CITY OF ALBUQUERQUE

April 14, 2023

Re: Wagoner Building
1800 Randolph Rd. SE
Traffic Circulation Layout
Engineer's 03-23-23 (M15-D008)

Based upon the information provided in your submittal received 03-27-23, the above referenced plan cannot be approved for Building Permit until the following comments are addressed:

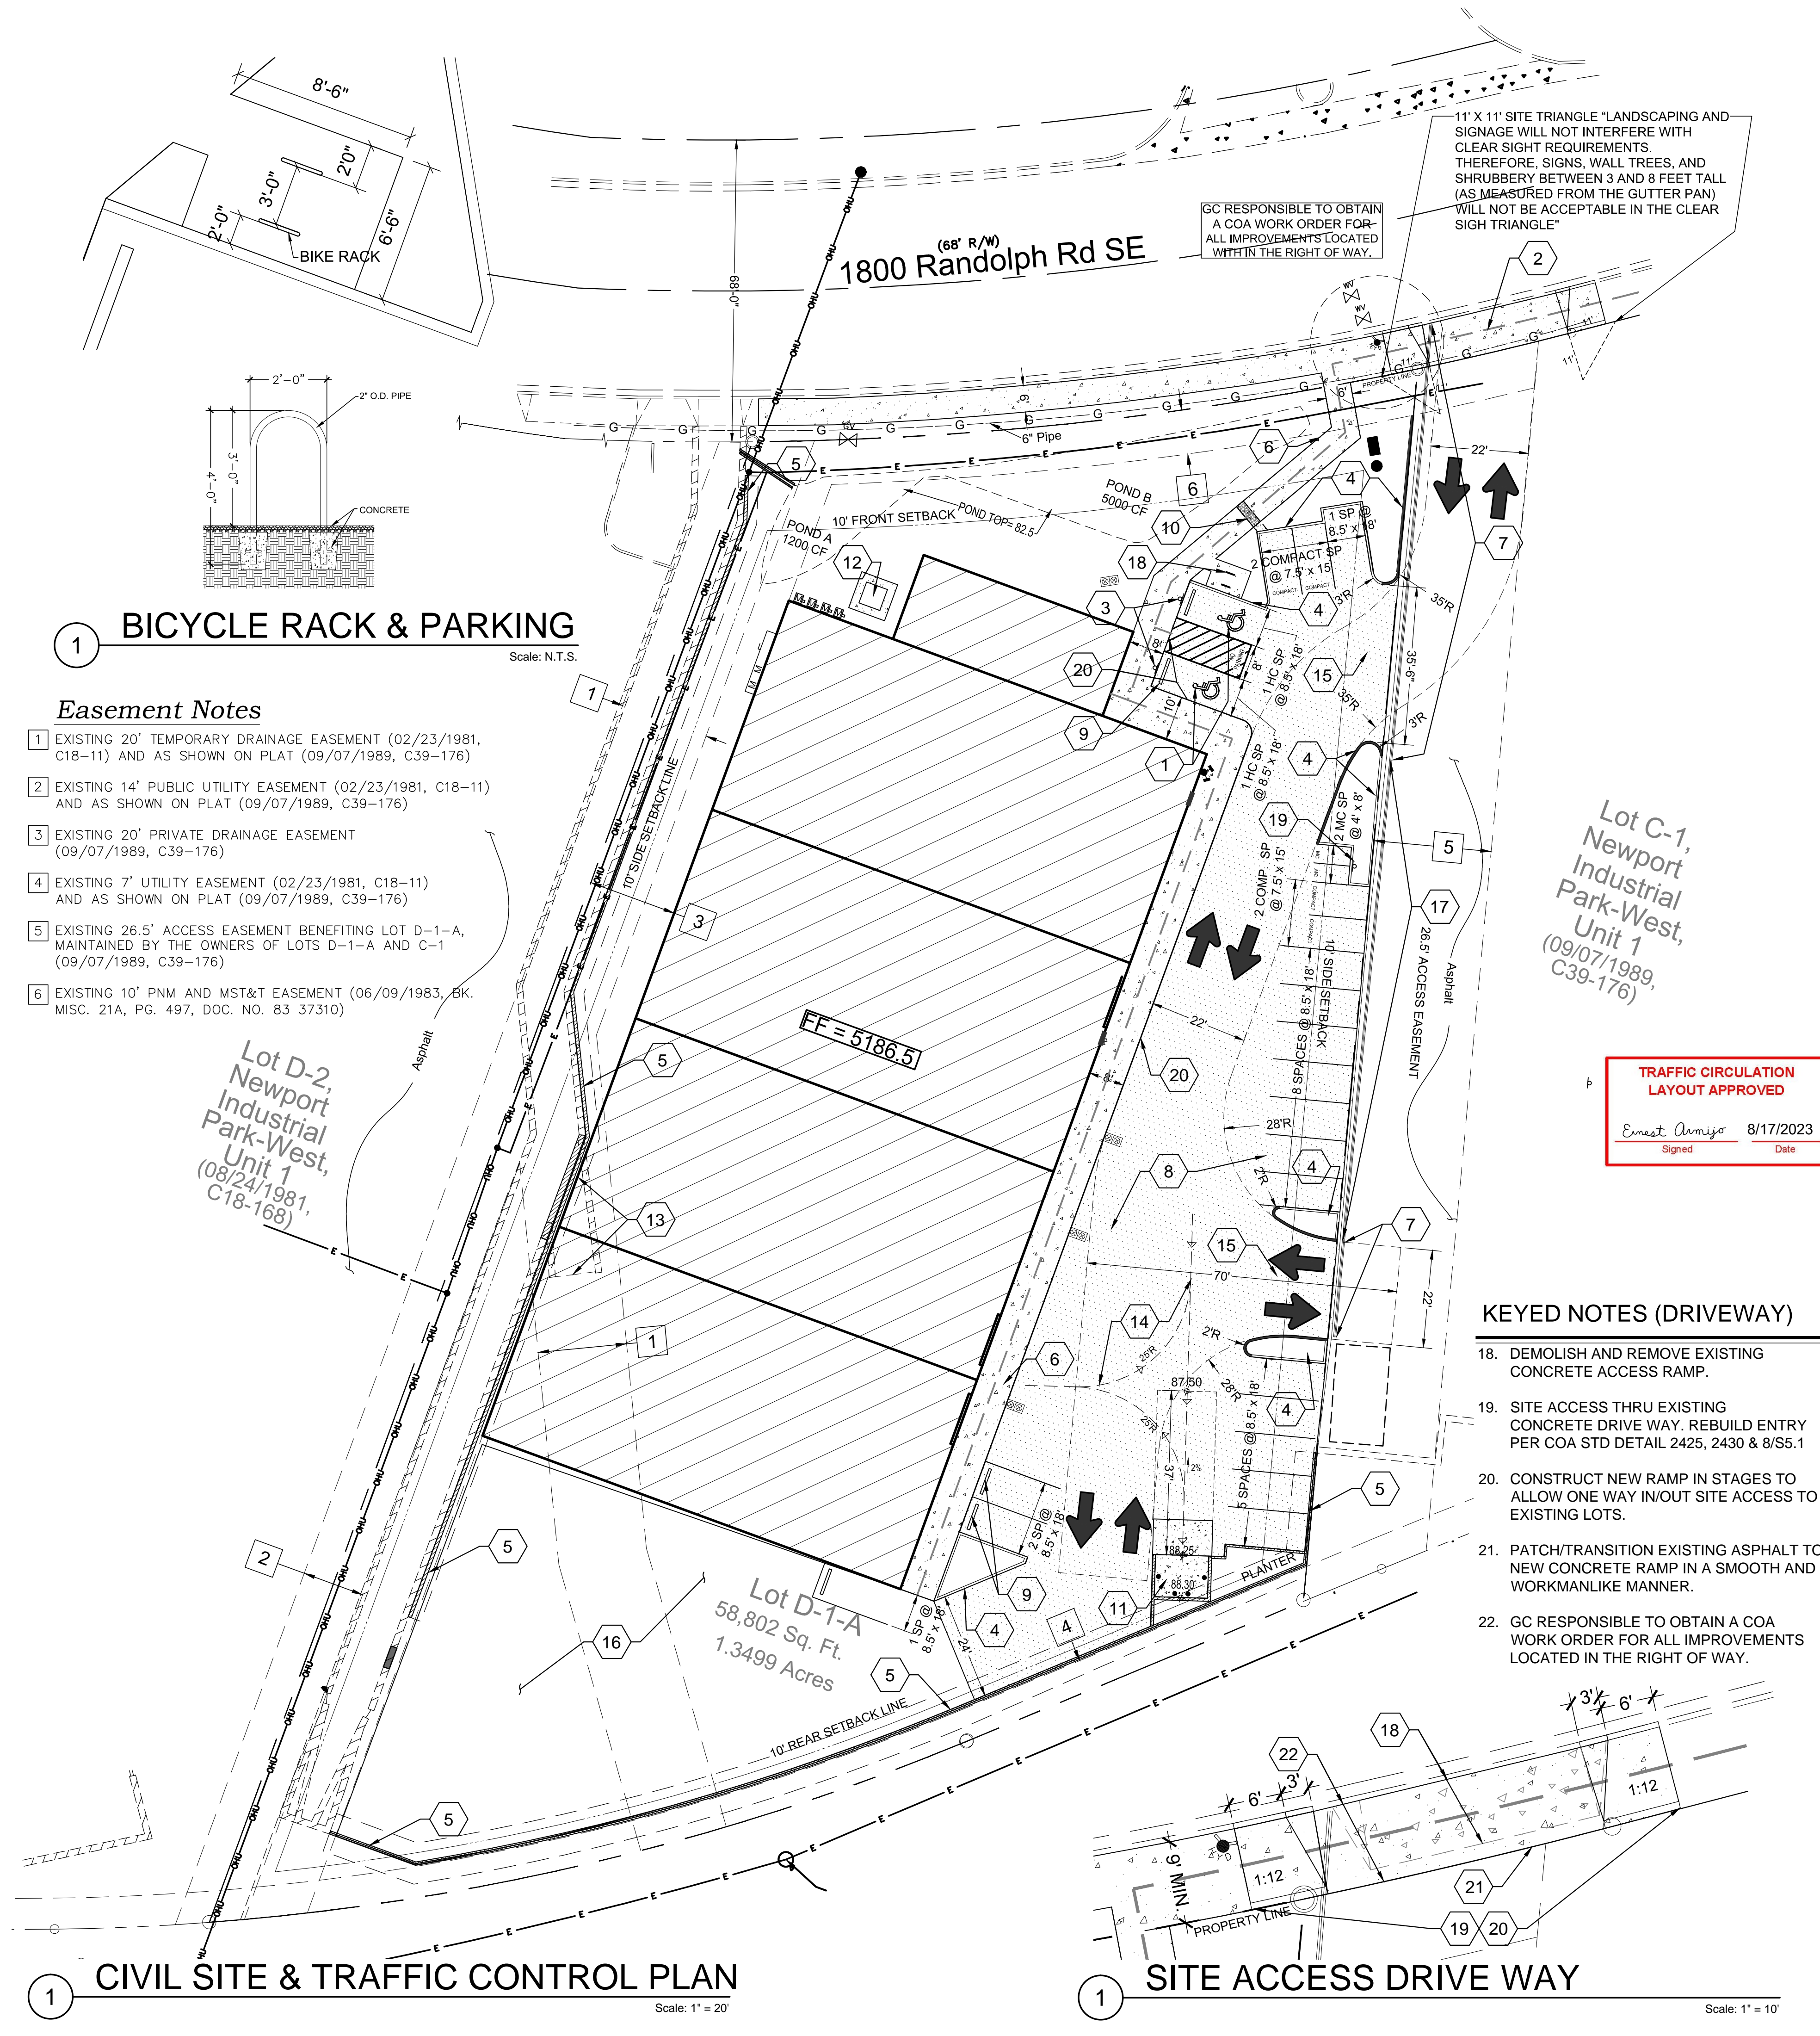
1. Identify all existing access easements and rights of way width dimensions.
2. Identify the right of way width, medians, curb cuts, and street widths on Randolph Rd. SE.
3. Please define the property line.
4. Please provide approved plat showing the access easement.
5. Please provide shared access agreement with the adjacent property.
6. Please provide details for the proposed sidewalk, and reference COA std dwg 2430.
7. On street parking is generally prohibited on Arterial street. Please note that Randolph is classified as Minor Arterial.
8. Minimum two-way Drive Aisle Width and two ways access's width should be minimum 22 ft.

9. Label the compact parking spaces by placing the words "**COMPACT**" on the pavement of each space.
10. The ADA accessible spaces must include an access aisle. Van accessible aisles should be 8ft wide; all others should be 5ft wide.

11. The pavement marking "MC" should be shown in the opposite direction for motorcycles entering the parking space.
12. All bicycle racks shall be designed according to the following guidelines:

13. Bicycle racks shall be sturdy and anchored to a concrete pad.
14. A 1-foot clear zone around the bicycle parking stall shall be provided.
15. Bicycle parking spaces shall be at least 6 feet long and 2 feet wide.

16. List radii for all curves shown; for passenger vehicles. Radius for delivery trucks, fire trucks, etc. is 25 ft. or larger.
17. All sidewalks along streets should be placed at the property line.

18. Curbing should be installed to delineate landscape, parking, and pedestrian ways and identify points of access. Please call out detail and location of barrier curb.

19. Refuse vehicle maneuvering shall be contained on-site. The refuse vehicle shall not back into the public right of way.; provide a copy of refuse approval.

20. Provide a copy of Fire Marshal approval.
21. Show the clear sight triangle and add the following note to the plan: "Landscaping and signage will not interfere with clear sight requirements. Therefore, signs, walls, trees, and shrubbery between 3 and 8 feet tall (as measured from the gutter pan) will not be acceptable in the clear sight triangle.
